Our Ref: 19/00818/ADJ
Your Ref: AL/107/18/PL

Ref: AL/107/18/PL

Proposal: Application for continued use for 3 No. approved permanent showpersons plots (temporary permission granted under AL/119/10/ & permanent permission granted under AL/10/14/PL), planning permission for a further 8 No. plots consisting of 4 No. existing & 4 No. new plots (to a maximum of 11 plots) with associated hard & soft landscaping, boundary treatment, lighting & associated works.

PROJECT: NYTON STABLES, ALDINGBOURNE, WEST SUSSEX	DATE: AUGUST 2018
DRAWING: LANDSCAPE PROPOSALS	SCALE: 1:1250 @ A3
	DRAWN: CHECKED:
	DRAWING NO: 18307-2-101

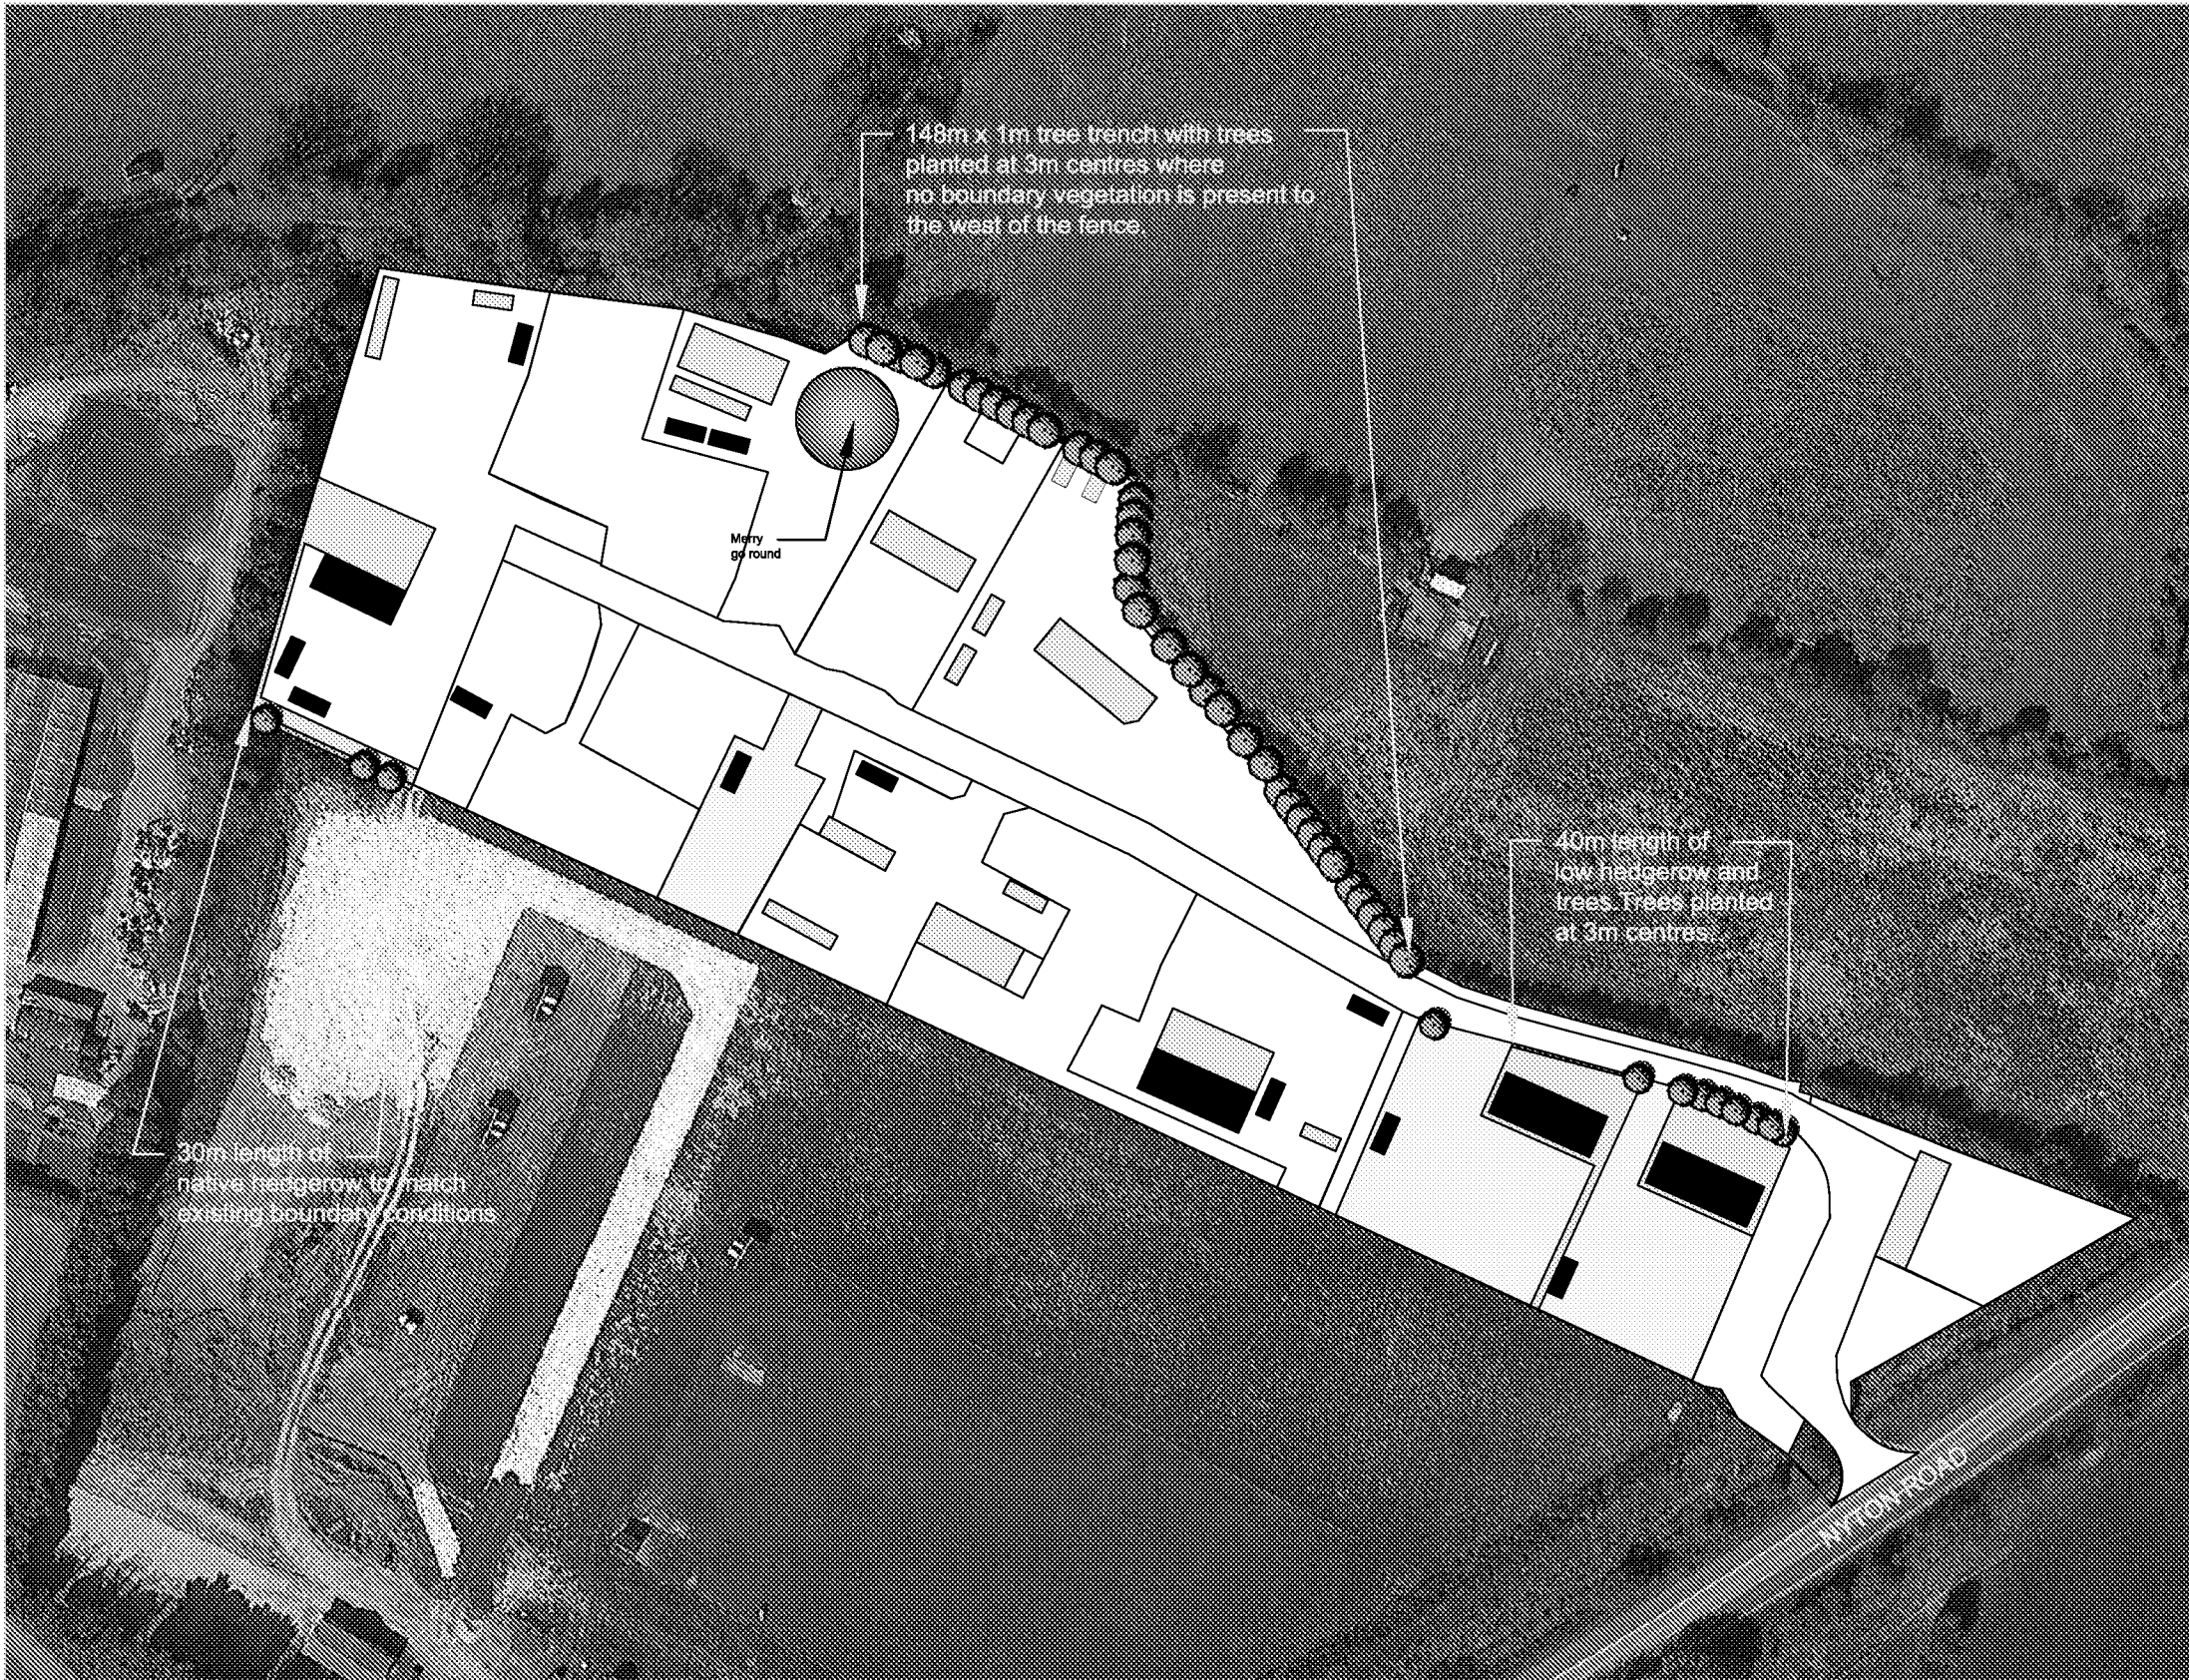
The site would be seen within the context of the countryside and would be located near Bridleway 292. Sensitive landscaping would be required to adequately screen the proposed development and to avoid material harm to landscape character. If Arun were satisfied with the proposed boundary vegetation, appropriate conditions should be applied to ensure that this is retained and maintained in a satisfactory condition.
